16 April 2021

Our Reference: SYD20/00773/06

Departments Reference: SSD-10479

**RESPONSE TO SUBMISSION FOR PROPOSED INDUSTRIAL BUILDING - 106-228
ALDINGTON ROAD, KEMPS CREEK**

1 PROPOSED MASTERPLAN 1 : 10000

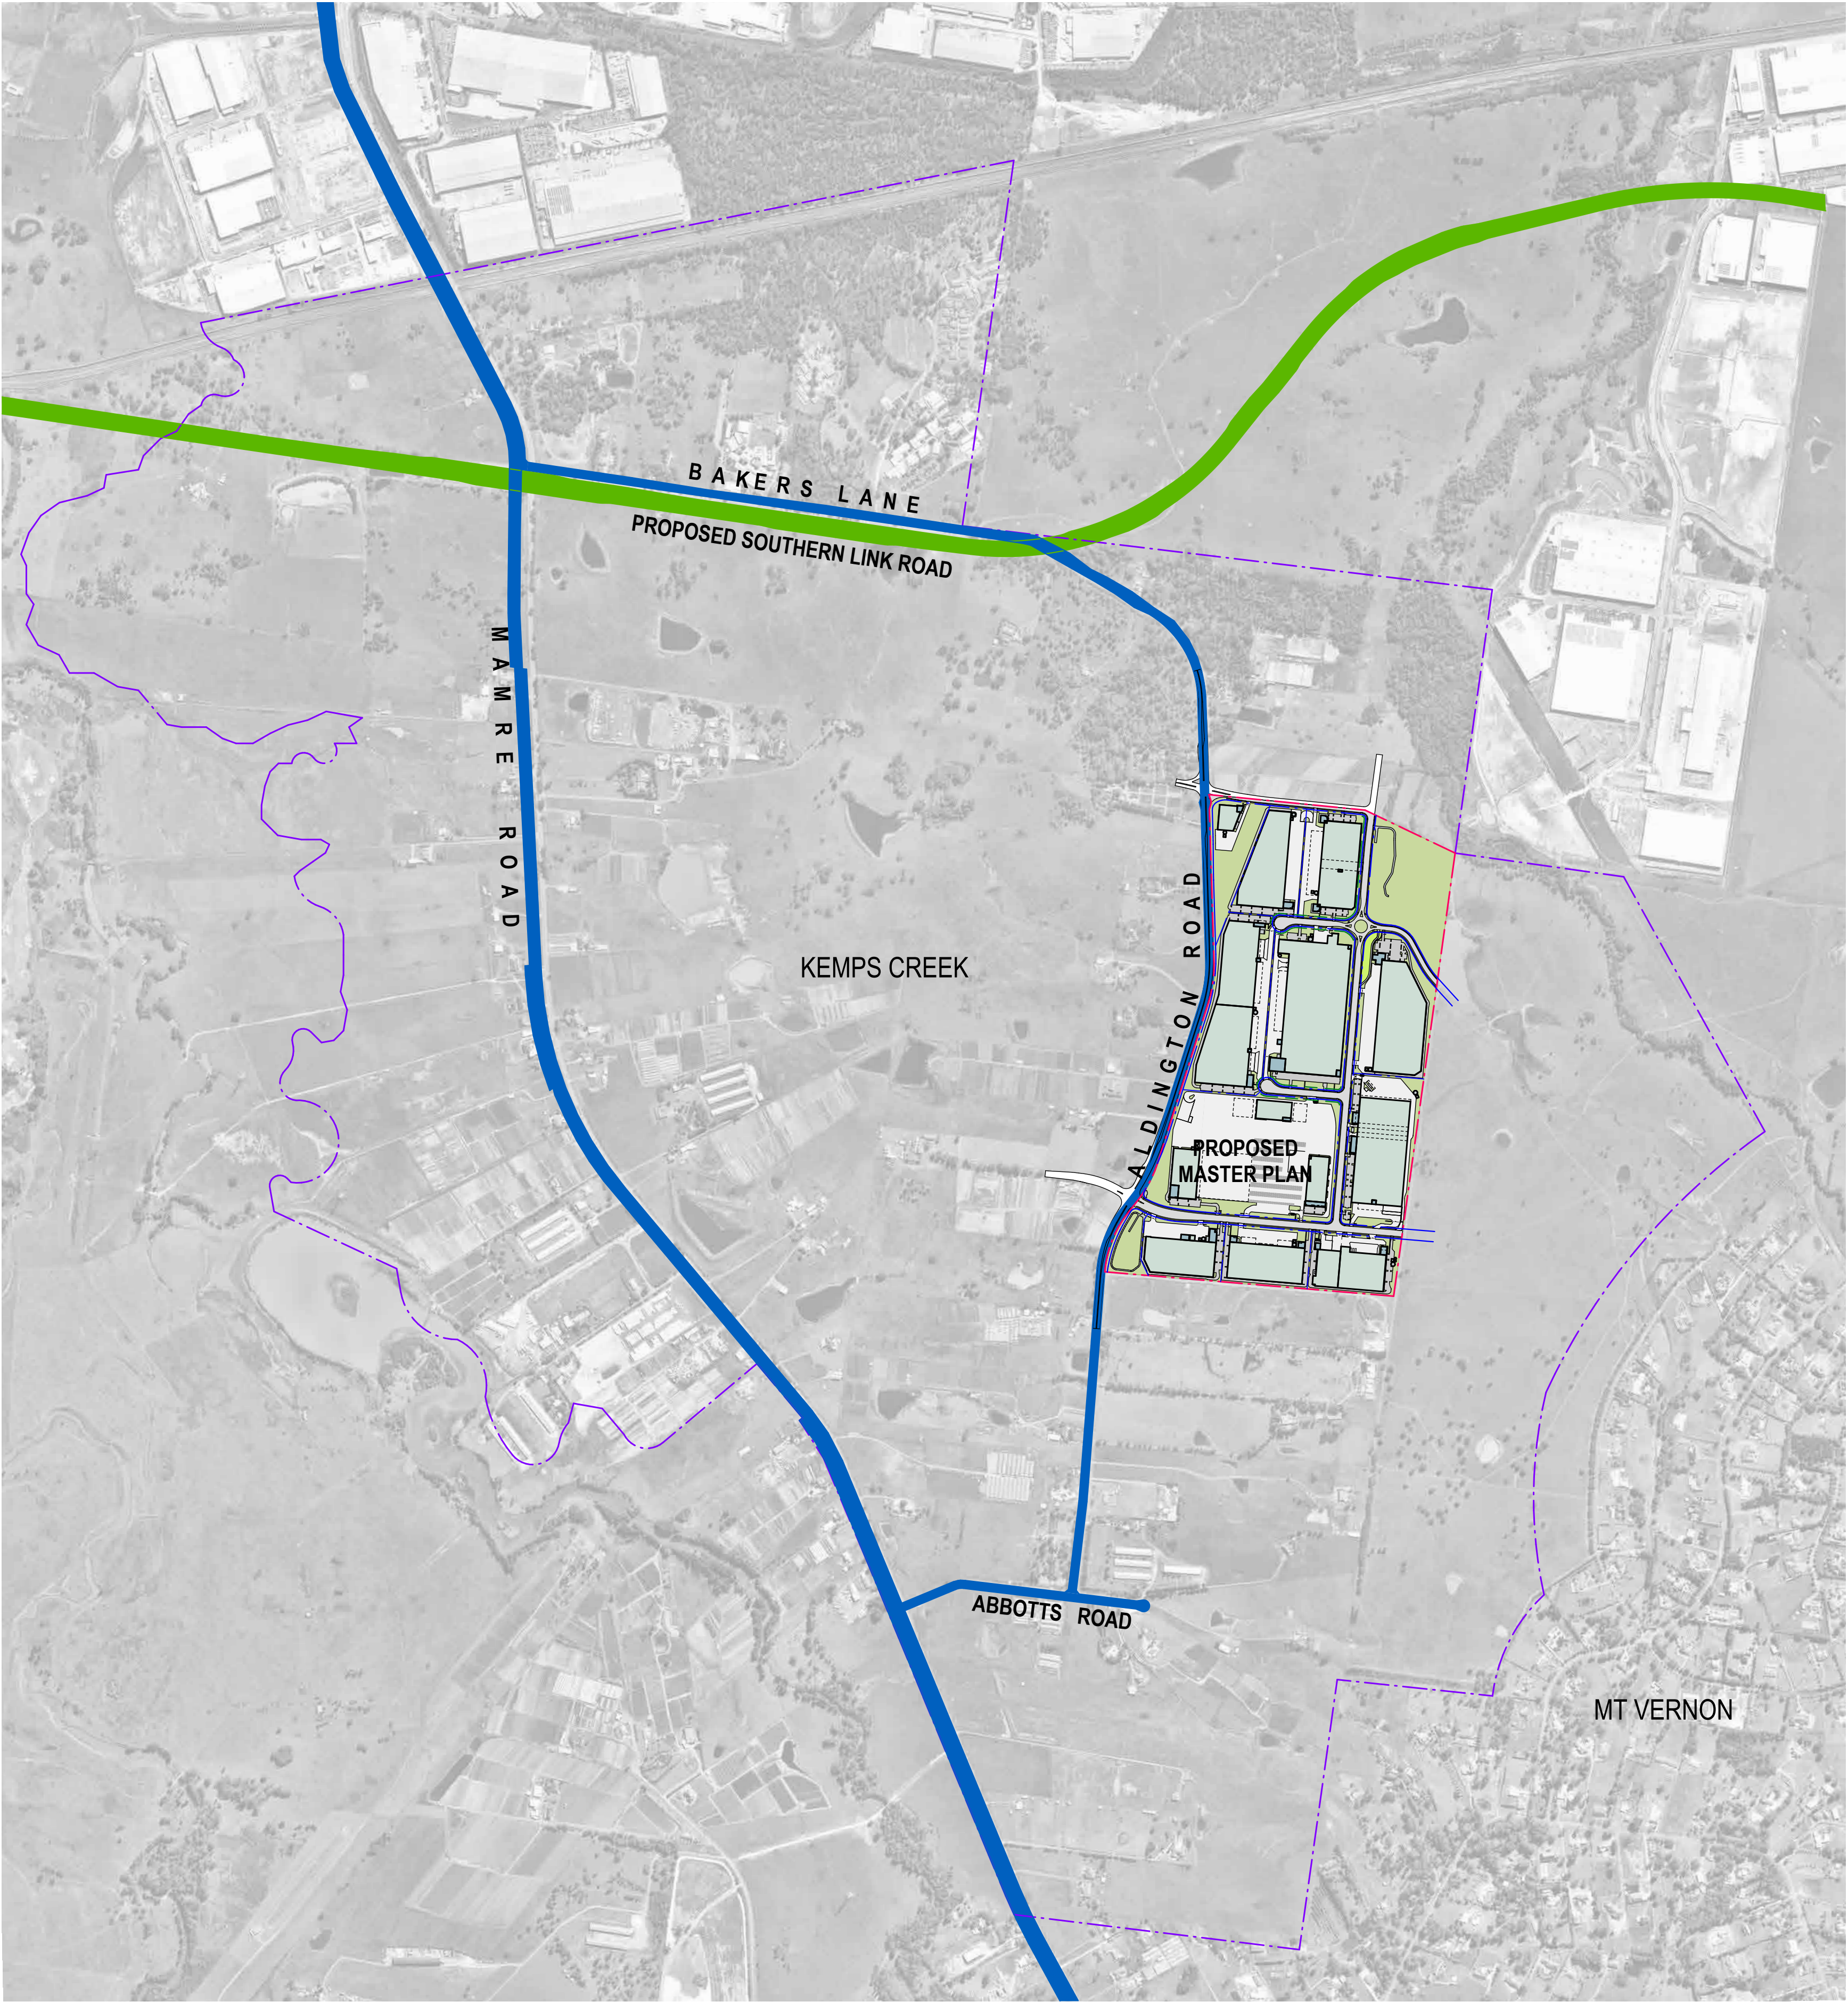
The road network proposed by this development consortium does not align with the draft Mamre Road Precinct (MRP) Development Control Plan (DCP). Figure 14 on page 53 of the MRP DCP shows the following roads adjoining the development:

- Two high order roads: one running east-west through the southern portion of the site, and the other along the site's northern boundary (shared with the adjoining landowner);

- A local industrial road running north-south through the site connecting the high order roads; and
- Open space edge run in the north-east corner of the site, running along to the RE2 zone boundary.

The high order road along the site's northern boundary and the open space edge run in the north-east corner of the site, running along to the RE2 zone boundary has not been included in the SSDA. The local industrial road running north-south through the site has been reduced in length.

The comment to Control 1, Section 2.1 of Appendix B – Table of Compliance – Draft Mamre Road Development Control Plan acknowledges that the industrial road access proposed varies from that identified in the MRP DCP and states that “this is considered acceptable given the proposal's ability to still meeting the Precinct Vision.” However, the section explaining how the proposal meets the Precinct Vision (comment to Control 3, Section 2.1 of Appendix B) does not highlight a reason acceptable to balance the variance of the proposed road access from that of the MRP DCP.

- c. Appendix B displays the northern access to the site is a T-intersection with Stop Control whilst the southern access follows a roundabout arrangement. The revised concept master plan document does not reflect this. These documents are to be updated to ensure that both are reflecting the actual proposed arrangement.

It is requested that before the development application is approved, the SSDA demonstrates the proposal meets the requirements of the roads within the MRP DCP.
